RFI

RFI #: 191
Date: 9/24/2012
Job: EB-02 Keller Springs Lofts
Phone: 877-777-5115

CC:
Subject: Request the depths of the planters

CC:
Subject: Veneer behind the scuppers in the fountain

A FOUNTAIN FEATURE AND ARBOR
RFD 191 + 214
1/2" = 1'-0"

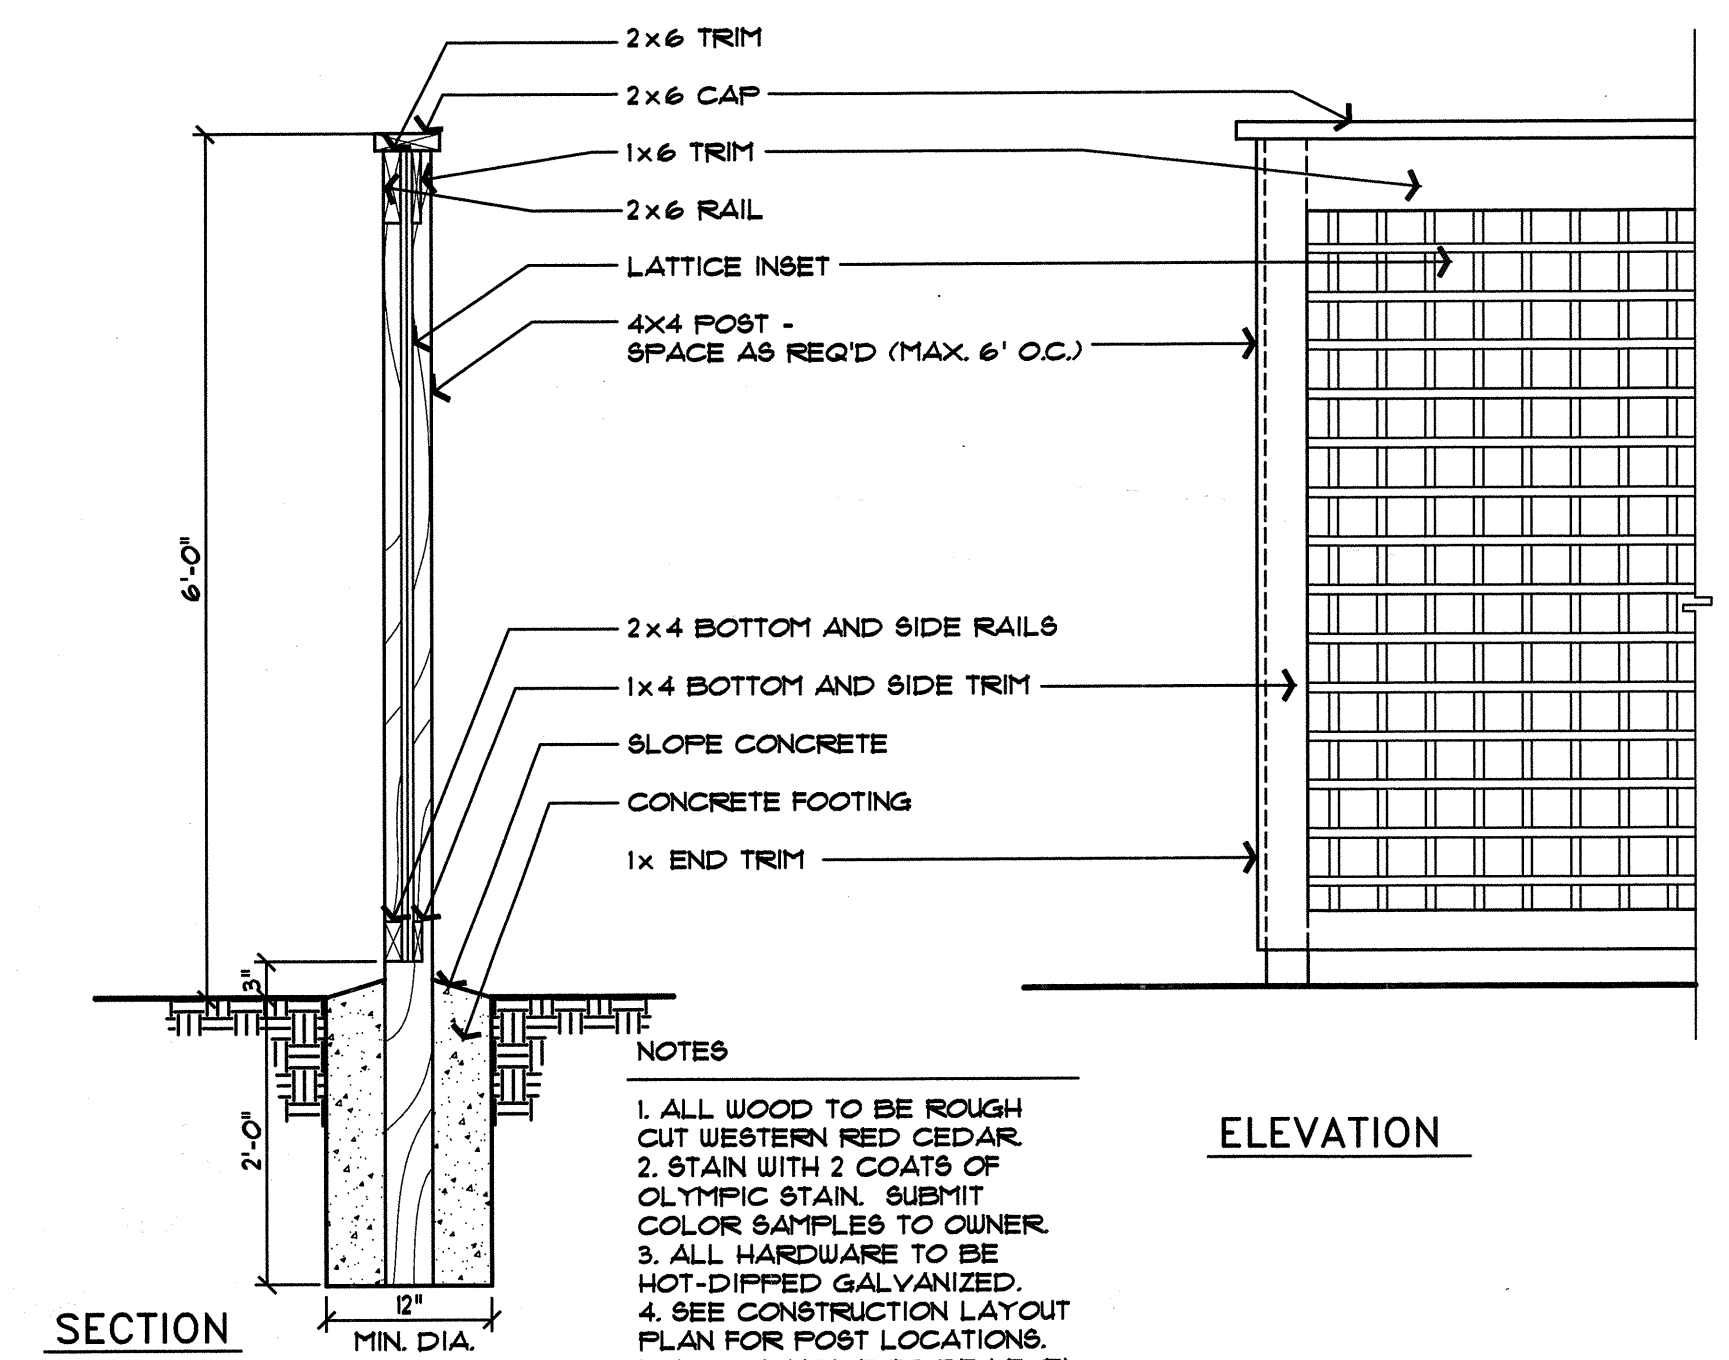
Request: Date Required: 10/1/2012
On sheet 9C the depth of the planters is missing. Please verify the depth of the planters. Please see attached marked up sheet 9C.

Response:
THE DEPTH OF PLANTERS IS SHOWN ON DETAIL A/9C. THE PLANTER ABOVE THE SCUPPERS IS 1'-0" DEPTH MEASURED FROM TOP OF NET CAST CAP. THE LARGER CENTER PLANTER IS 1'-6" DEPTH MEASURED FROM TOP OF NET CAST CAP. UNLESS THERE IS A CONFLICT WITH THE SCUPPERS (OR ABOVE FEATURES), THE MINIMUM DEPTHS SHOWN ON THE DETAIL SHOULD BE MAINTAINED.

Request: Date Required: 12/14/2012
PLEASE SEE ATTACHED PAGE 9C
THE AREA BEHIND THE SCUPPERS ARE BLANK AND HAVE NO INDICATION OF THE VENEER
AND THE SIDE VIEW IS STILL CALLING FOR SPLIT FACE CMU . . . IS THIS IN ERROR. SEE OTHER COMMENTS ON
ATTACHMENT.

Response:
Fountain feature to be lueders stone and not split face block. Detail callout was not updated/ corrected when the detail was revised previously. the area below scuppers is a void space and open to the other side(see through). The section at scuppers on detail A/9C is a cut through of the planter basin bridge that is spanning the 2'-0" opening.
